## WEST SUSSEX COUNTY COUNCIL CONSULTATION

| <b>DATE:</b>                    | 18 March 2019                                                                                                                                                                                                                                                                                                 |
| <b>LOCATION:</b>                | Land off Burndell Road Yapton.                                                                                                                                                                                                                                                                                |
| <b>SUBJECT:</b>                 | Y/98/18/RES<br><br>Approval of reserved matters (access, appearance, landscaping, layout and scale) following outline permission Y/19/16/OUT for 108 residential dwellings, with associated parking, road/footway/cycleway provision, open space, landscaping, surface water attenuation and ancillary works. |

DRAWING TITLE
Garages, Carports
& Ancillary Buildings
Details

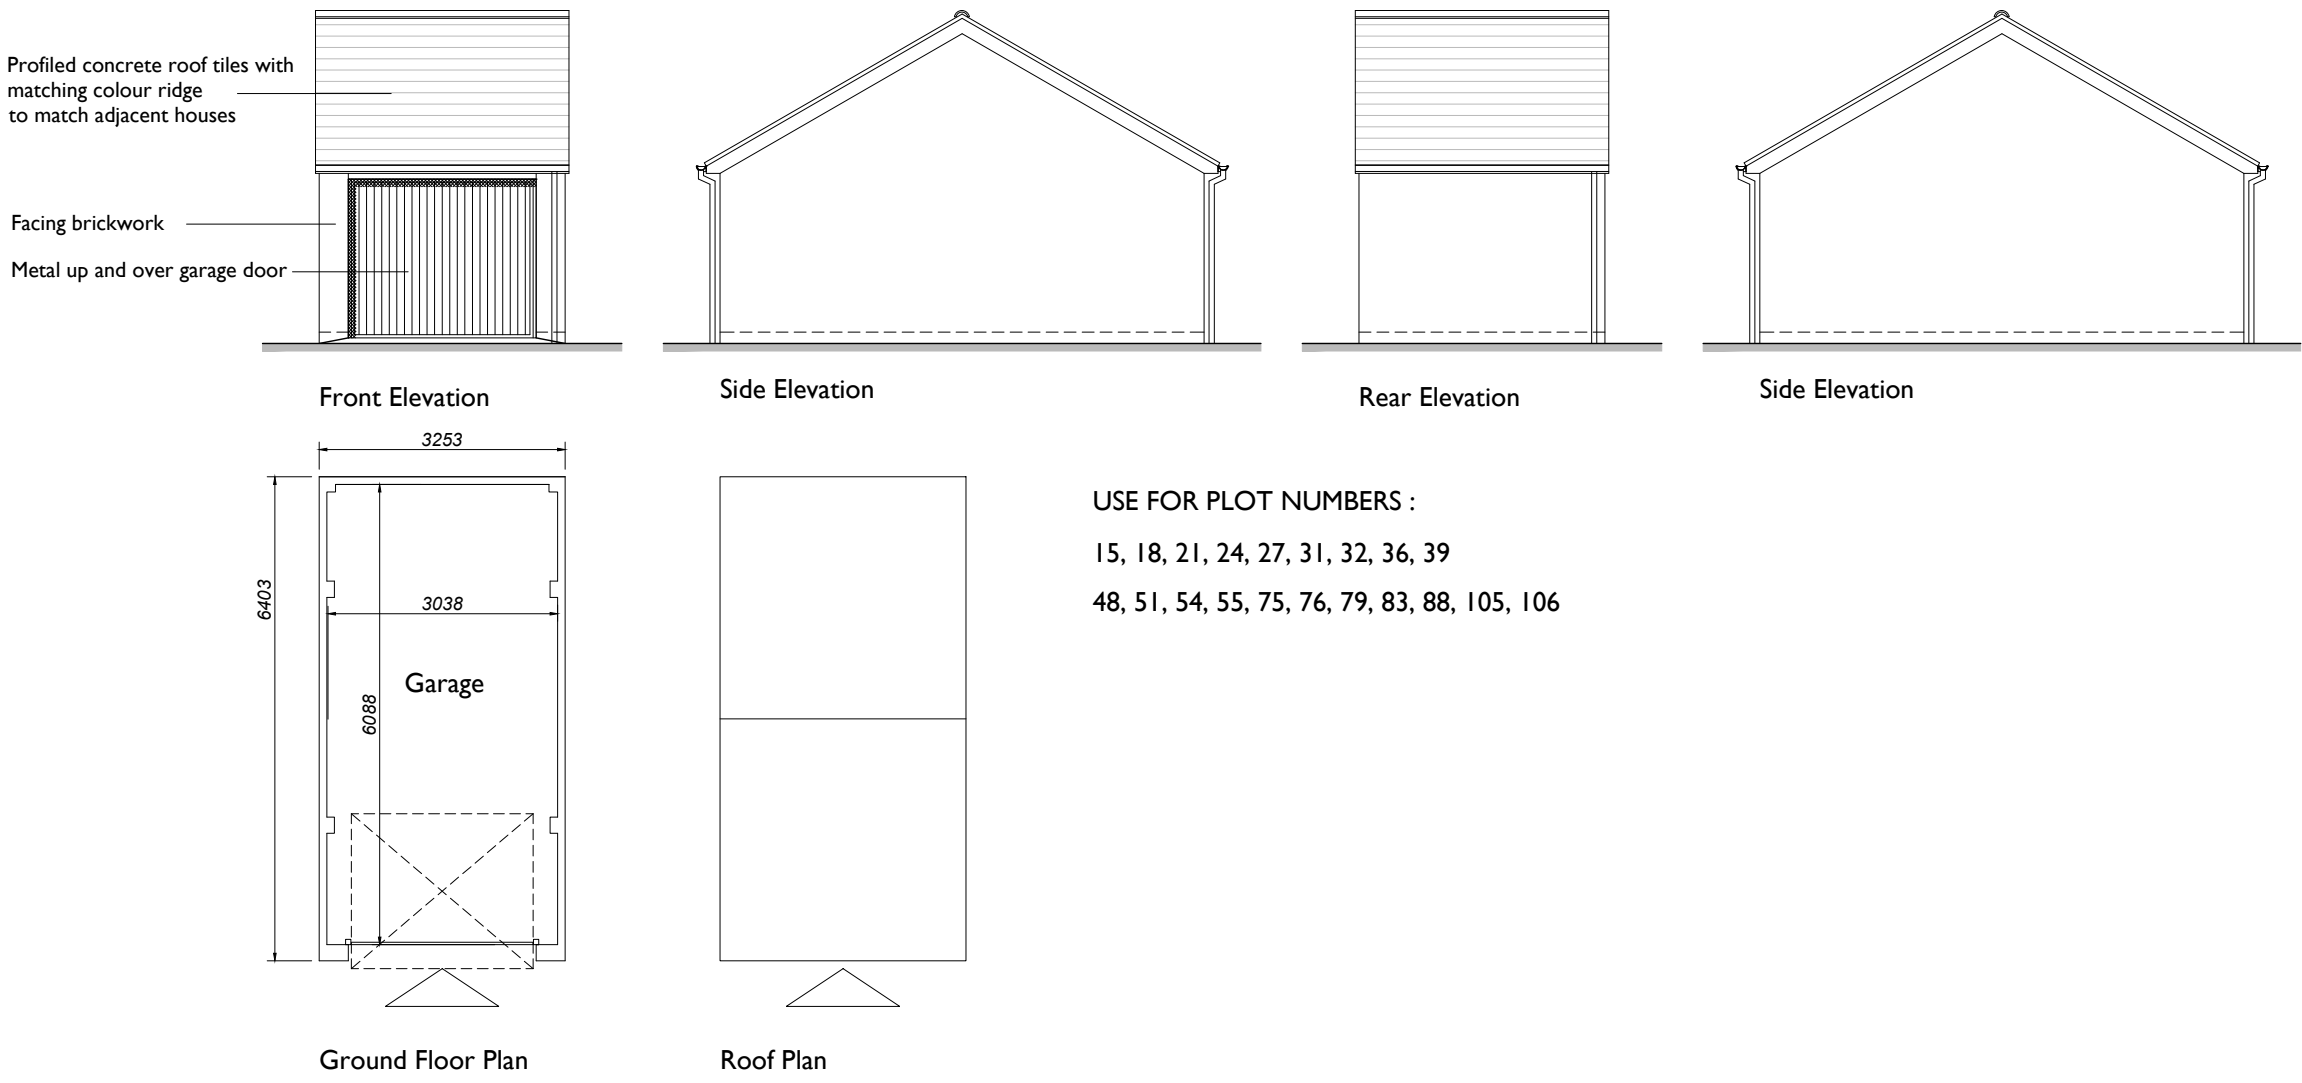
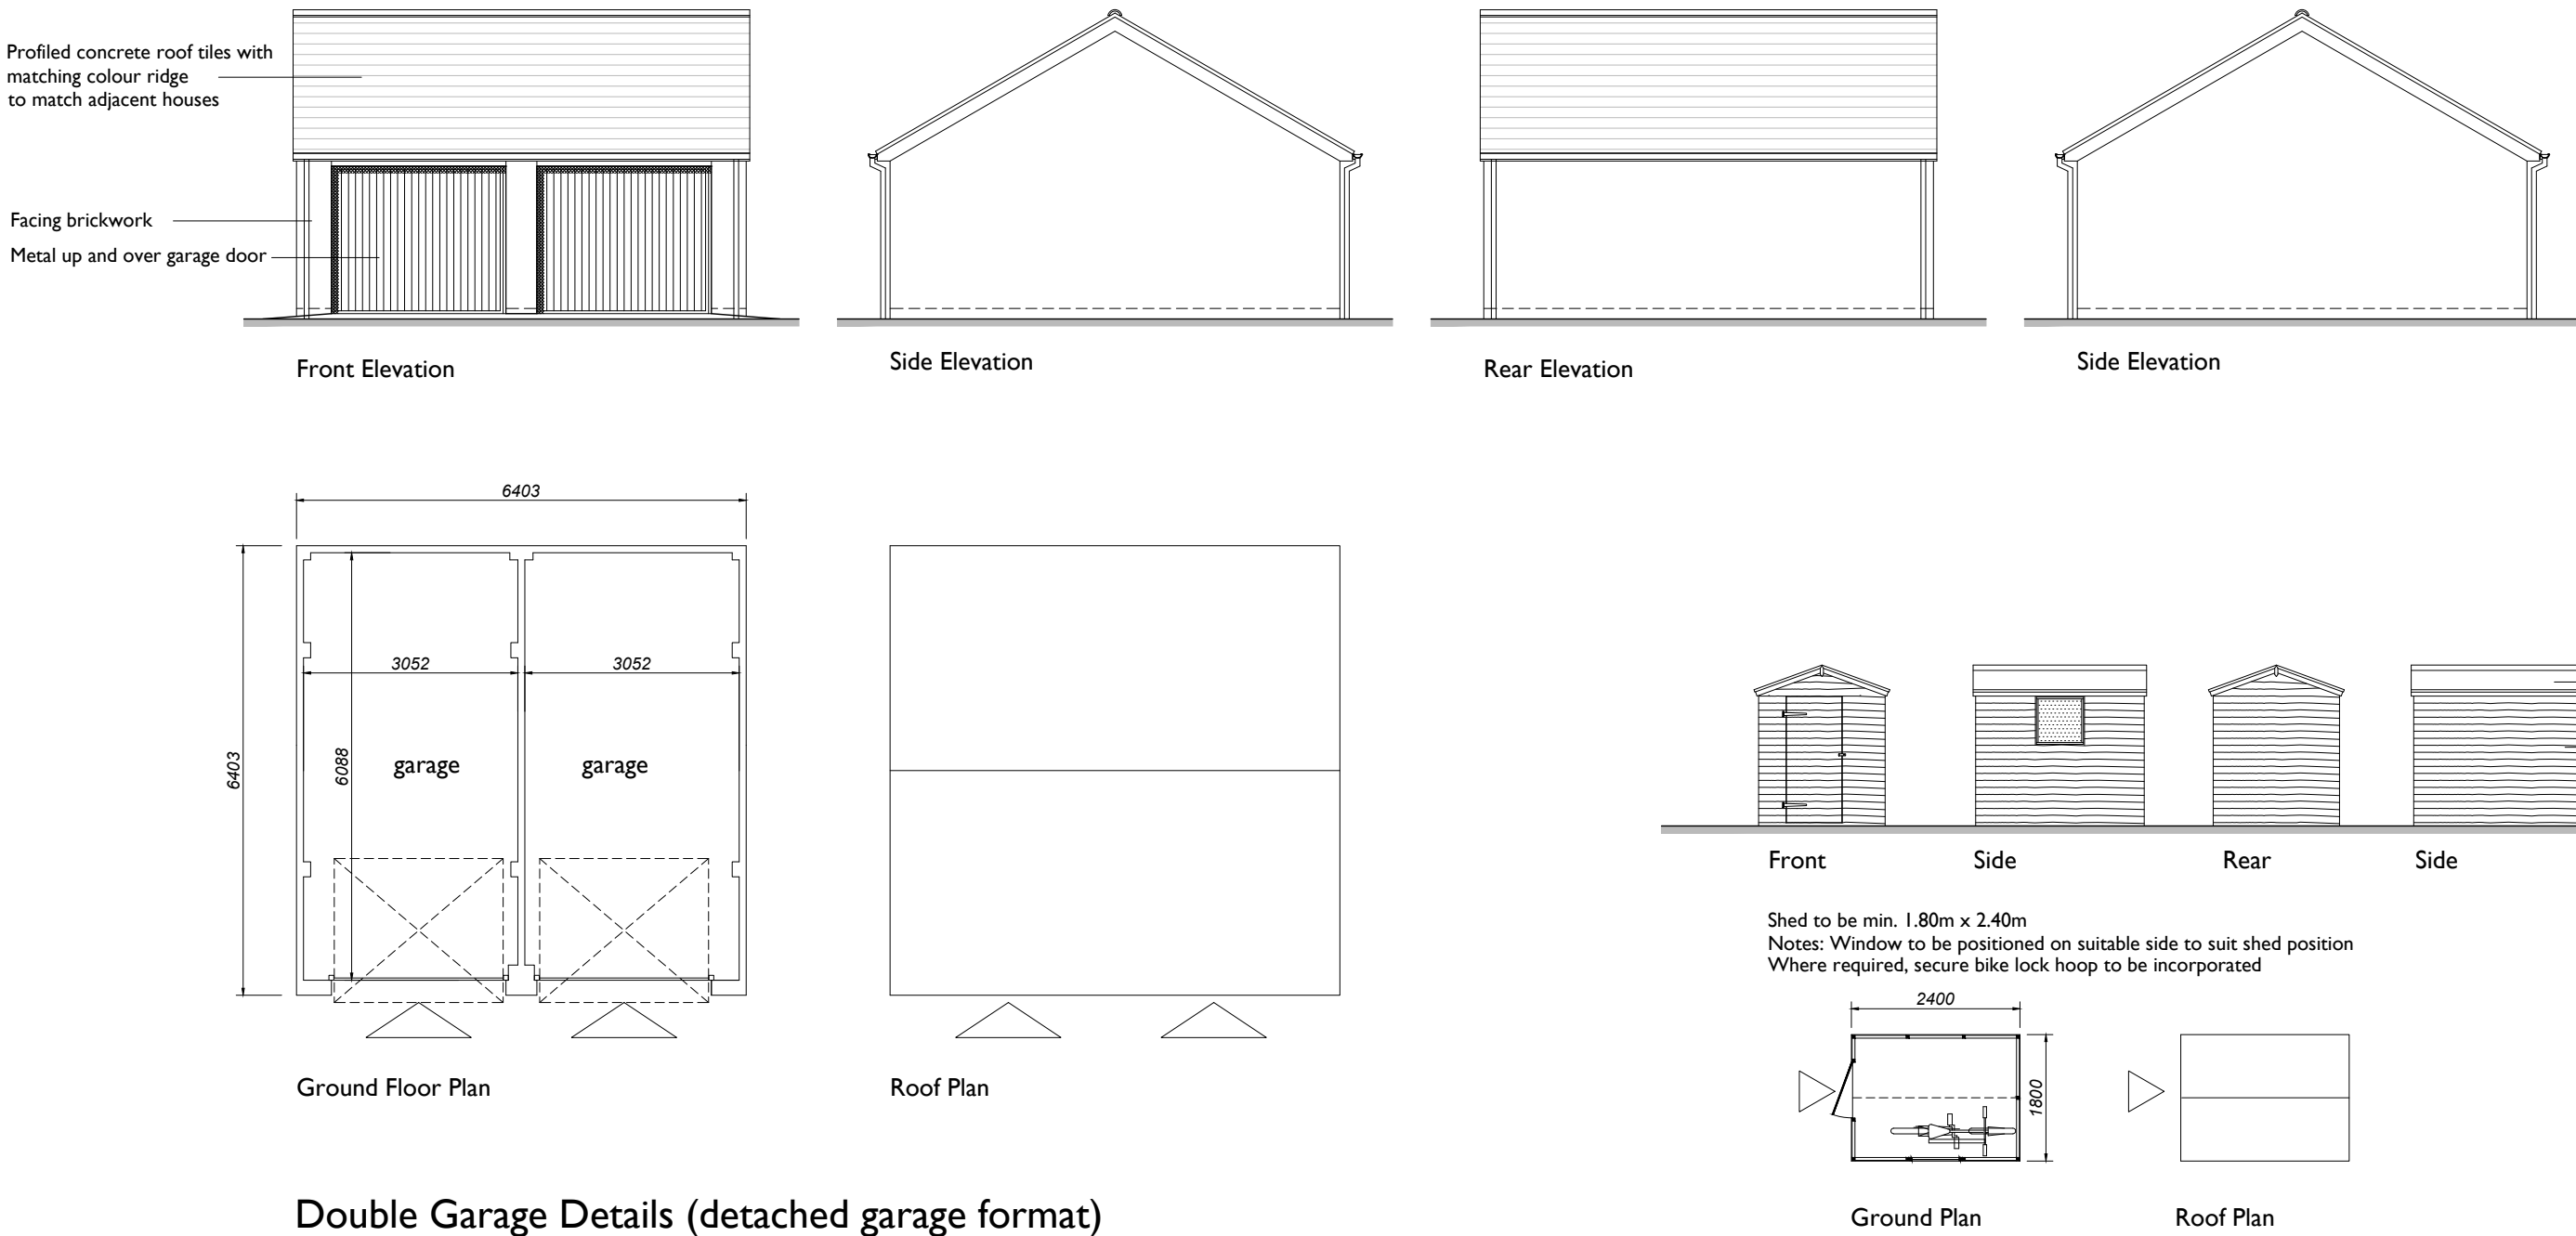
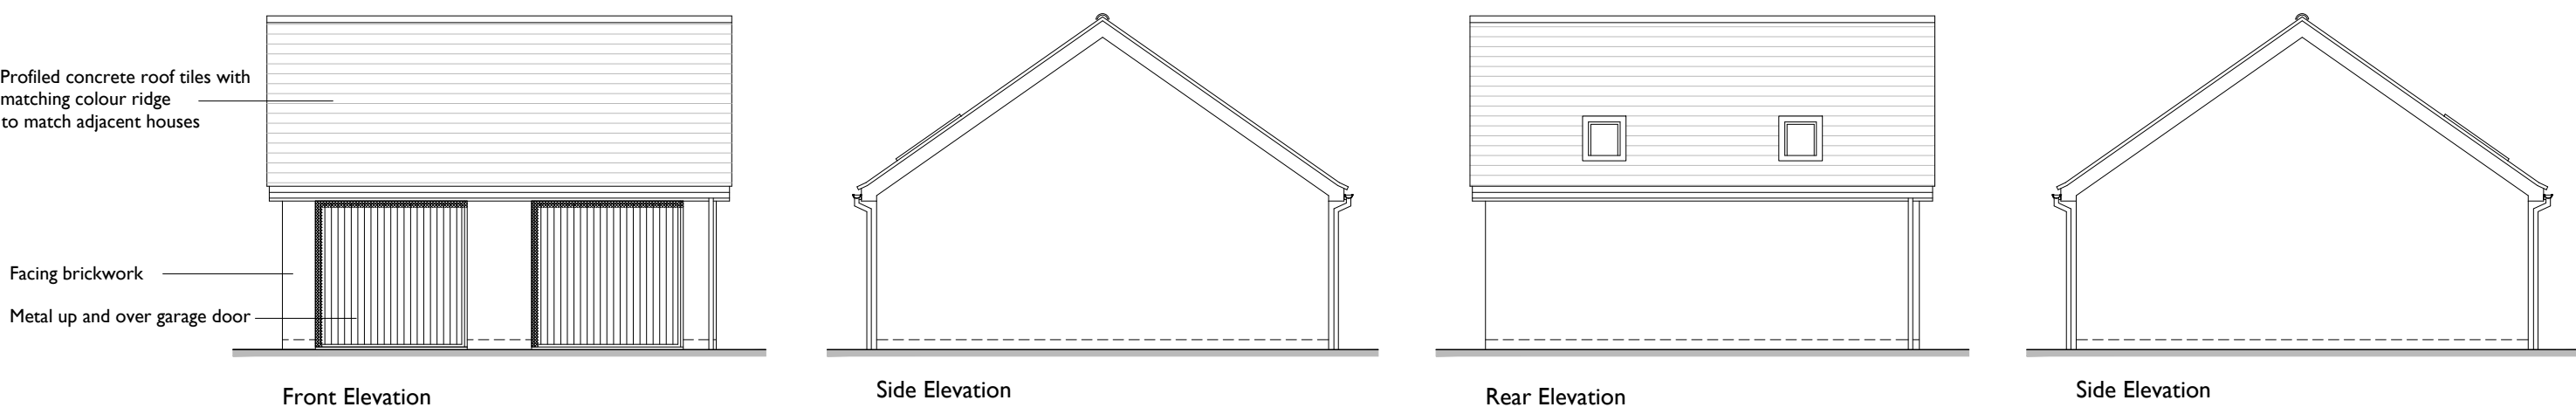
- 3. Condition 22 (car parking)** – Dimensions for allocated, unallocated and visitor parking spaces appear to be acceptable. The Parking Technical Note supplied with the planning application states the dimensions of the garages as being 6.0m long by 3.0m wide and this is now appears confirmed looking at the latest drawings.
